Application for a non-material amendment following a grant of planning permission.

PROPOSED TWO-STOREY REAR EXTENSION AND REVISED GARAGE
ROOF DESIGN

BN/19/09

TO SET BACK BY 150^{mm} THE EXTENSION ON THE REAR
ELEVATION (SOUTH EAST)

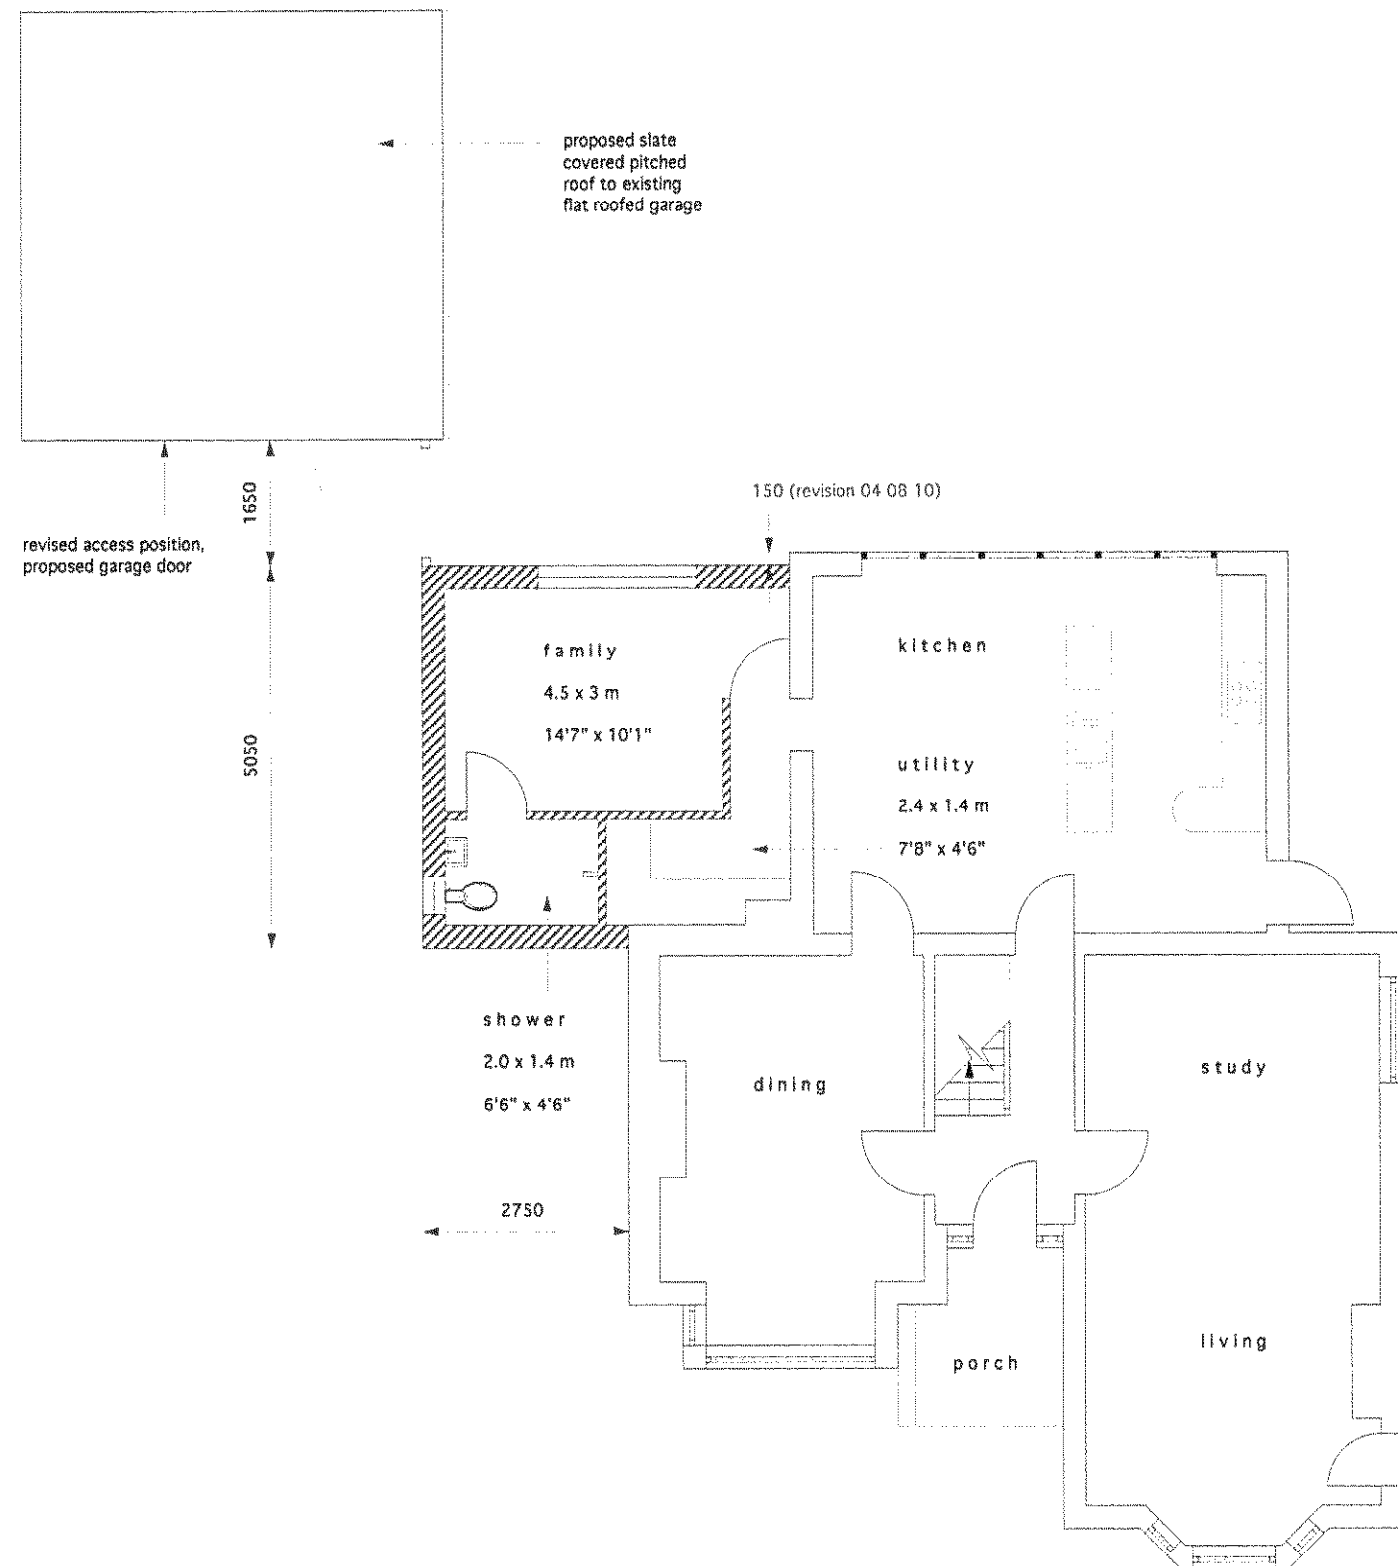
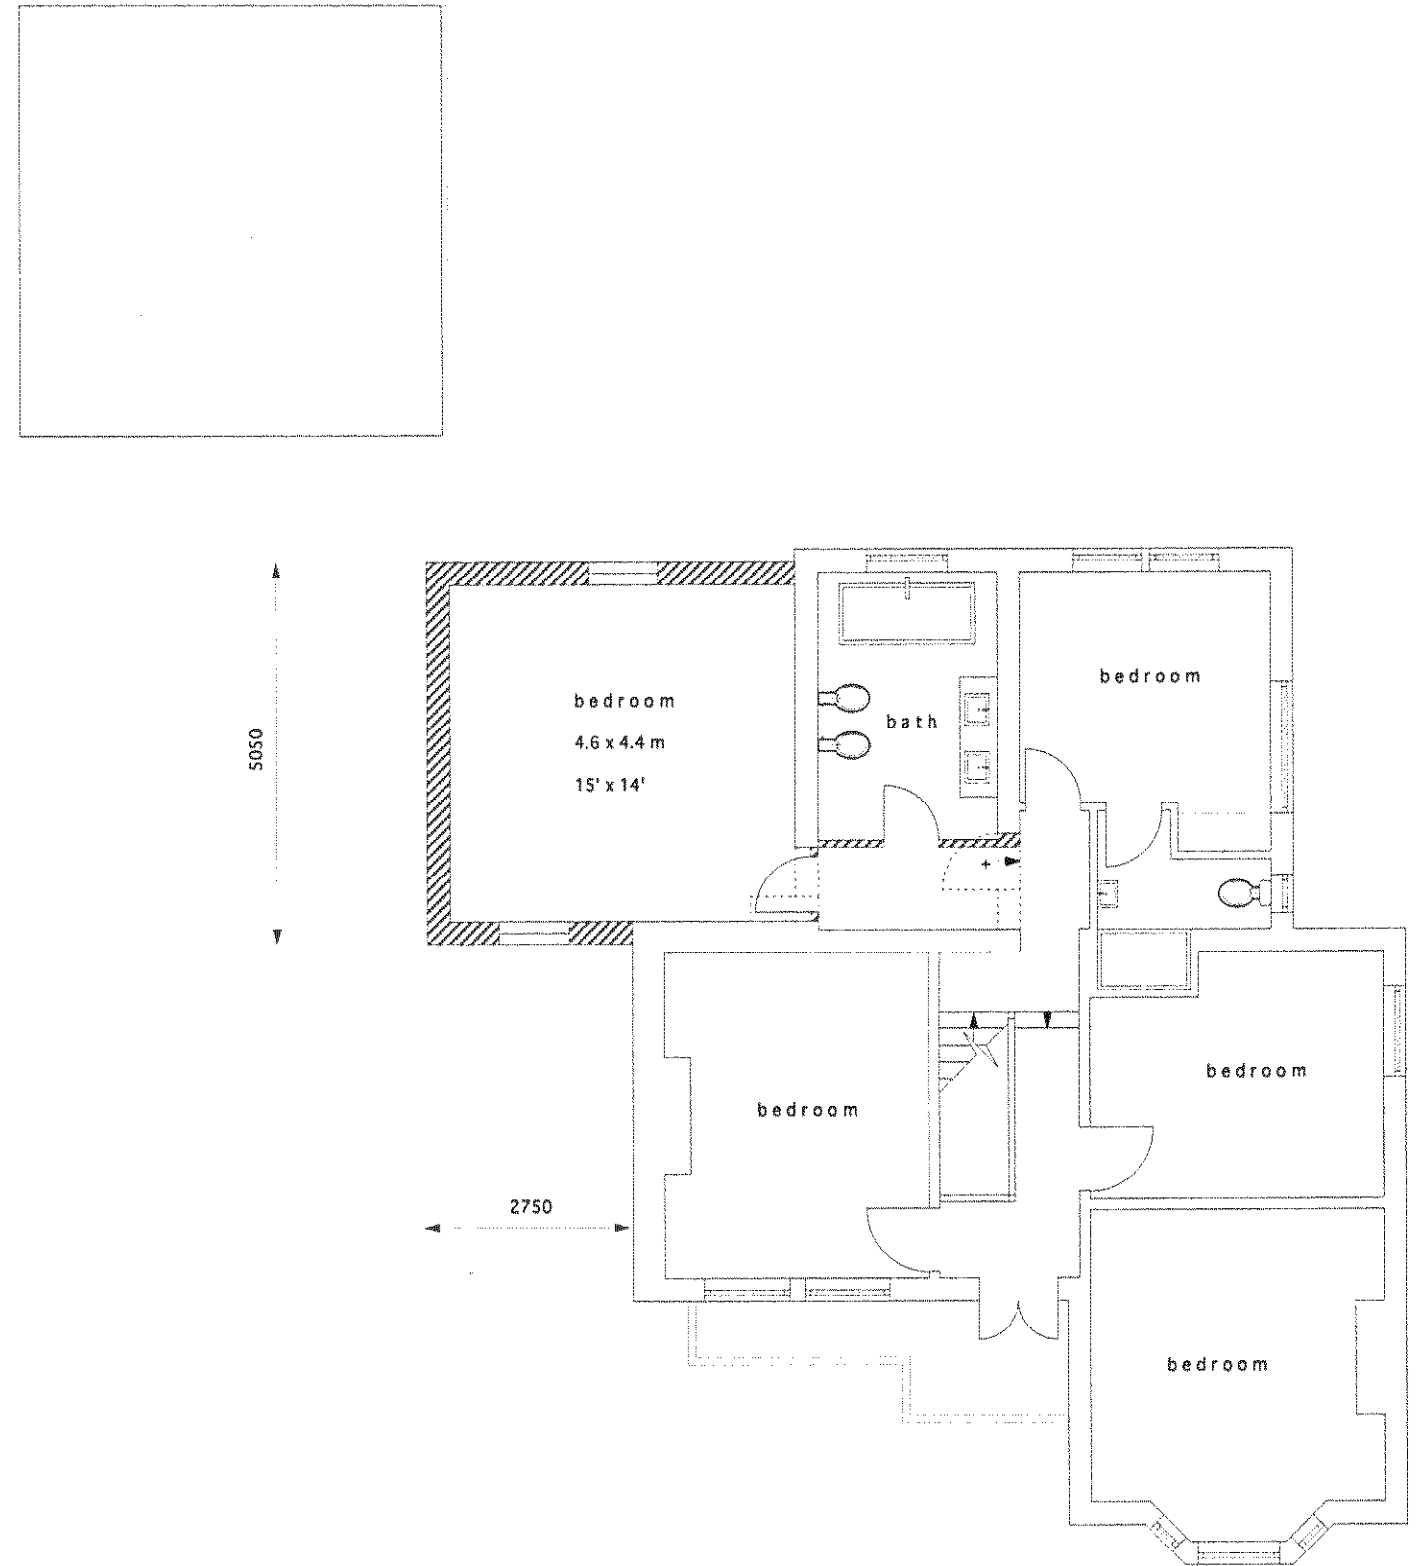
SETTING BACK 150^{mm} TO MAIN HOUSE TO IMPROVE AESTHETICS OF REAR
ELEVATION
